From: Nicola Swann [REDACTED]
Sent: 20 December 2021 11:11
To: Planning.Responses <Planning.Responses@arun.gov.uk>
Subject: Pagham responses

P/153/21/RES. Land south of Summer Lane and West of Pagham Road Pagham. Approval of reserved matters (appearance, layout, landscaping and scale) following outline planning permission P/140/16/OUT for the erection of 375 No dwellings, together with public open space, play space, drainage, parking and associated infrastructure, landscape, ancillary and site preparation works, with access off Pagham Road. This site may affect a Public Right of Way.

P/167/21/RES. Land south of Summer Lane and West of Pagham Road Pagham. Approval of reserved matters (appearance, layout, landscaping and scale) following outline planning permission P/140/16/OUT for the erection of 375 No dwellings, together with public open space, play space, drainage, parking and associated infrastructure, landscape, ancillary and site preparation works, with access off Pagham Road (alternative to P/159/21/RES). This site may affect a Public Right of Way.

The Council wishes to OBJECT to these applications for the following reasons:

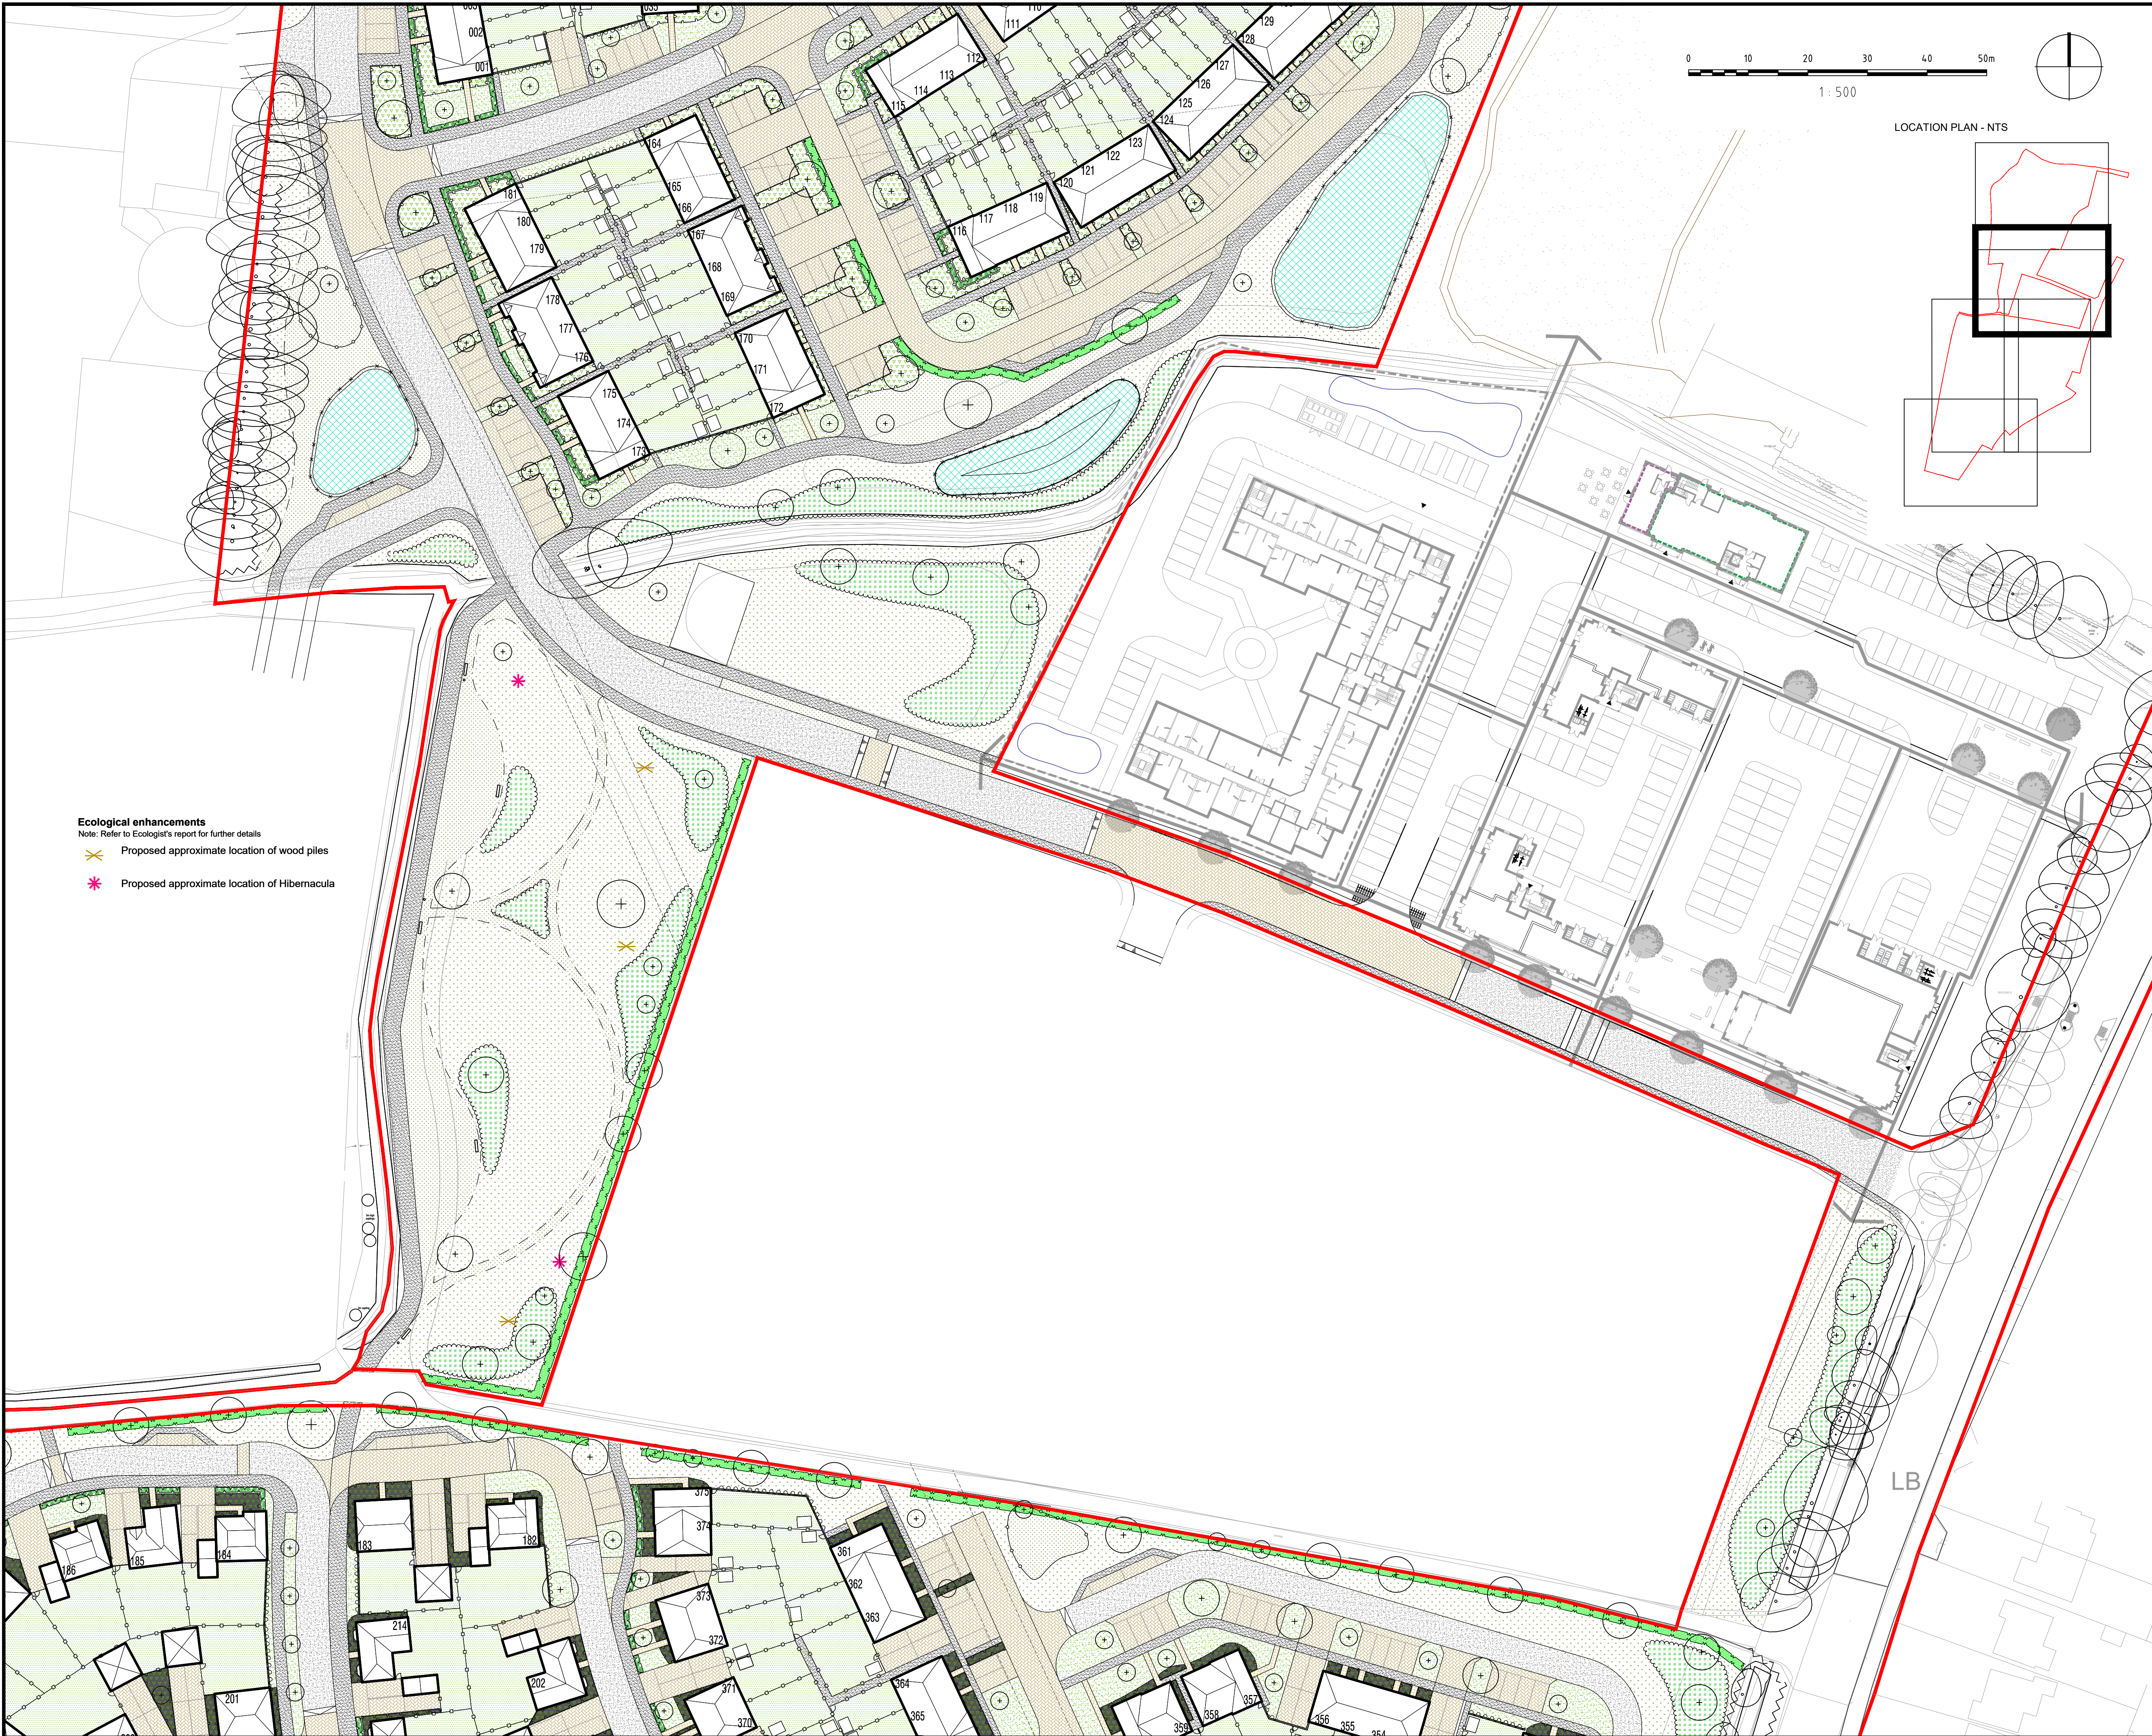
During discussions with developers, the Council had been advised that there would be bungalows fronting onto Pagham Road. There did not appear to be any bungalows in the development.

There is insufficient detail about how the allotments will be laid out – where is the provision for parking? Will there be power/water?
